AENC-NG-CNS-REP-0252

Norwich to Tilbury

**Document: 8.3.36 Draft Statement of Common Ground - Priory Farm
Airfield**

Priory Farm Airfield

Image A15.2.1 Climb-out over Overhead Line - Low and High Performance Single Piston Engine Aircraft

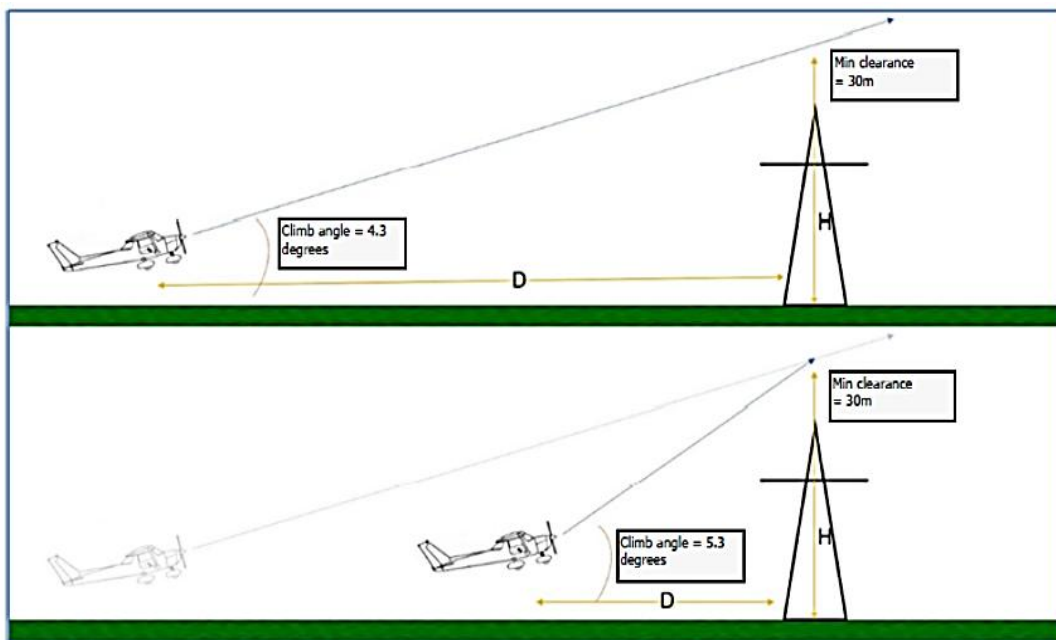
| ID | Issue | Priory Farm Airfield position (including date) | National Grid response (including date) | Relevant documentation |
|-----|--|---|---|------------------------|
| 6.3 | Aviation Impact Assessment Methodology and Key Assumptions | <p>There appears to be an overreliance on theoretical modelling:</p> <ul style="list-style-type: none"> All of your clearance assumptions rely on idealised aircraft performance and standardised circuit behaviour. But real-world conditions – wind shear, engine issues, human error, bird activity – are NOT factored in. Your assessment assumed ideal climb-outs and fixed circuits, but light aircraft regularly depart or return using modified paths based on wind, traffic, or emergencies. A model that only covers textbook operations does not address real safety. There has been no meaningful consultation with the pilots who fly from here every week. The assessments do not reflect the way real flights operate, | <p>National Grid does not consider any key information to be missing or preventing progression of engagement. (January 2026)</p> <p>National Grid’s Aviation Impact Assessment methodology has been developed to enable site-specific impact assessments for aerodromes potentially impacted by the Project. Its primary aim is to evaluate risks of collision, predominantly during take-off and approaches and including forced landing risks, with the proposed overhead line alignment representing a new obstacle within proximity of aerodromes. Operational safety impacts arising from potential increases to risks of bird strike, wind turbulence and electromagnetic forces as a result of the Project are also considered.</p> <p>As previously stated, National Grid’s approach recognises and responds to CAP793 recommendations, albeit with the understanding its broad parameters of 150ft/2000m are generalised suggestions for owner and operator consideration in relation to airfield design, rather than absolute requirements to be addressed by prospective</p> | |

| ID | Issue | Priory Farm Airfield position (including date) | National Grid response (including date) | Relevant documentation |
|----|-------|---|---|------------------------|
| | | <p>particularly for microlights or low-performance aircraft.</p> <ul style="list-style-type: none"> We would also add that Priory Farm has published procedures both online and through popular navigation aids such as SkyDemon and Pooleys. Utilising these aids it is difficult to see how the pylons can have anything but a significant adverse effect on both our 500' and 1,000' circuits. It should also be obvious that the proximity of Tibenham leaves zero margin for movement eastwards. <p>(July 2025)</p> <p><u>Priory Farm raised concerns that details of impact assessments have not been shared with the operator or published.</u> (August 2025)</p> | <p>developers. The methodology enables a bespoke appraisal, appropriate to each aerodrome, that considers a range of factors in addition to the height and location of the proposed overhead line alignment, including: runway length and orientation in relation to the overhead line; aircraft types, performance, flight paths and operational procedures (determined from published information, as well as from previous engagement) and the surrounding context in terms of topography, existing obstacles (including other overhead lines) and neighbouring aerodromes (recognising operational deconfliction constraints).</p> <p>The assessments consider whether the Project alignment infringes Obstacle Limitation Surfaces (OLS) as specified under the CAA's CAP 168 regulations for licensed aerodromes, recognising this to be a best practice measure for obstacle assessment and treatment, whilst not a regulatory requirement for unlicensed aerodromes. If CAP168 measures are met, the proposed overhead line alignment is considered to have an acceptable impact on the aerodrome's operations and no further</p> | |

| ID | Issue | Priory Farm Airfield position (including date) | National Grid response (including date) | Relevant documentation |
|-----|--|--|--|---|
| 6.4 | Proposed Project Alignment and Impact Assessment Conclusions | <p>Safety concerns regarding the proximity of the overhead line to Priory Farm Airfield, relating to overflight clearances, including in instances of engine failure. Concerns regarding impacts on existing operational procedures including existing circuits. (May 2024)</p> <p>We see little evidence that “Deconfliction of interactions in flight procedures between</p> | <p>National Grid’s Aviation Impact Assessment conclusions for Priory Farm Airfield include that, whilst the Project will represent a new obstacle in the vicinity, CAP168 OLS standards are met, with the exception of a minor penetration of the Inner Horizontal Surface (IHS). Distances from the runway ends to the proposed overhead line alignment are assessed as sufficient to enable safe clearance margins during take-off and landing. Whilst current circuits would involve</p> | <p>Technical Overflight Clearance Drawings - 01_220101_92_Priory Airstrip RevA; Airfield Impact Assessment Summary – Priory Farm v3</p> |

| ID | Issue | Priory Farm Airfield position (including date) | National Grid response (including date) | Relevant documentation |
|----|-------|--|---|------------------------|
| | | <p>the aerodrome and Tibenham aerodrome has been considered within the assessment”.</p> <ul style="list-style-type: none"> • There is an admitted penetration of protected airspace (Inner Horizontal Surface),however ”minor” it may be described; • The guidance of CAP 793,which is directly relevant to unlicensed airfields such as ours, is being sidelined; • The operational margins presented are based on idealised circuits and standardised climb-outs/approaches, and do not reflect real-world variability, especially under emergency conditions; • The proposed mitigation - that we consider altering our operational procedures – places the burden of risk mitigation on the airfield, rather than the developer introducing the hazard. <p>Priory Farm Airfield is used by low-performance,light and microlight aircraft</p> | <p>overflight of the overhead line, this is assessed to be from a safe height, in accordance with normal practices.</p> <p>Furthermore, it is assessed that the position of the overhead line would have minimal impact on aircraft returning to the airfield in an emergency. Deconfliction of interactions in flight procedures between the aerodrome and Tibenham aerodrome has been considered within the assessment.</p> <p>(March 2025)</p> <p>National Grid recognises that, as a result of its presence as an obstacle, the Project would increase risk to aerodrome operations. Through the aerodrome-specific impact assessments, National Grid has detailed and quantified the extent of any impacts, and in the case of Priory Farm, has concluded impacts are not significant as clearances are sufficient to enable safe operational margins. National Grid has sought Operator agreement of risk acceptability. As the Operator has not agreed the impact assessment conclusions, National Grid has requested feedback on what risk thresholds would be <u>acceptable</u>.</p> | |

| ID | Issue | Priory Farm Airfield position (including date) | National Grid response (including date) | Relevant documentation |
|-----|---------------------|---|---|------------------------|
| | | <p>which operate with far narrower margins than your modelling implies. Emergencies, go arounds, and weather-related deviations are all routine occurrences. Adding tall infrastructure within the CAP 793 safeguarding radius presents an unacceptable elevation in operational risk.</p> <p>We therefore restate our objection to the current alignment and urge a revision that fully avoids CAP 793 breach and eliminates incursion into the IHS.</p> <p>(July 2025)</p> | <p>(January 2026)</p> | |

| ID | Issue | Priory Farm Airfield position (including date) | National Grid response (including date) | Relevant documentation |
|----|-------|---|---|---------------------------|
| | | | <p>changes are considered likely to be necessary.</p> <p>(March 2025)</p> <p><u>National Grid is receptive to feedback regarding the methodology and key assumptions, and welcomes the opportunity to test these using 'real world' data to ensure a robust and objective approach. Notwithstanding National Grid's stated position in relation to CAP 793 parameters, we would be grateful for Operator clarification of what would be an acceptable clearance, and further welcome the sharing of Operator data, including published information to ensure it has been duly considered.</u></p> <p><u>(August 2025)</u></p> <p><u>National Grid has submitted a Review of Aviation Impact as an appendix to the Environmental Statement accompanying the DCO application. This appendix describes National Grid's aviation assessment scope, approach and conclusions, as outlined in</u></p> | |

| ID | Issue | Priory Farm Airfield position (including date) | National Grid response (including date) | Relevant documentation |
|-----|--|--|--|---|
| | | | <p>relation to Priory Farm within this SoCG. Should the DCO application be accepted for examination, the appendix will be published by the Planning Inspectorate, and National Grid will share the document with operators. (September 2025)</p> <p>6.15.A2 Environmental Statement Appendix 15.2 - Review of Aviation Impact explains how relevant CAA guidance, as well as consultation with aviation bodies and operators, has informed the development of the assessment methodology. (January 2026)</p> | |
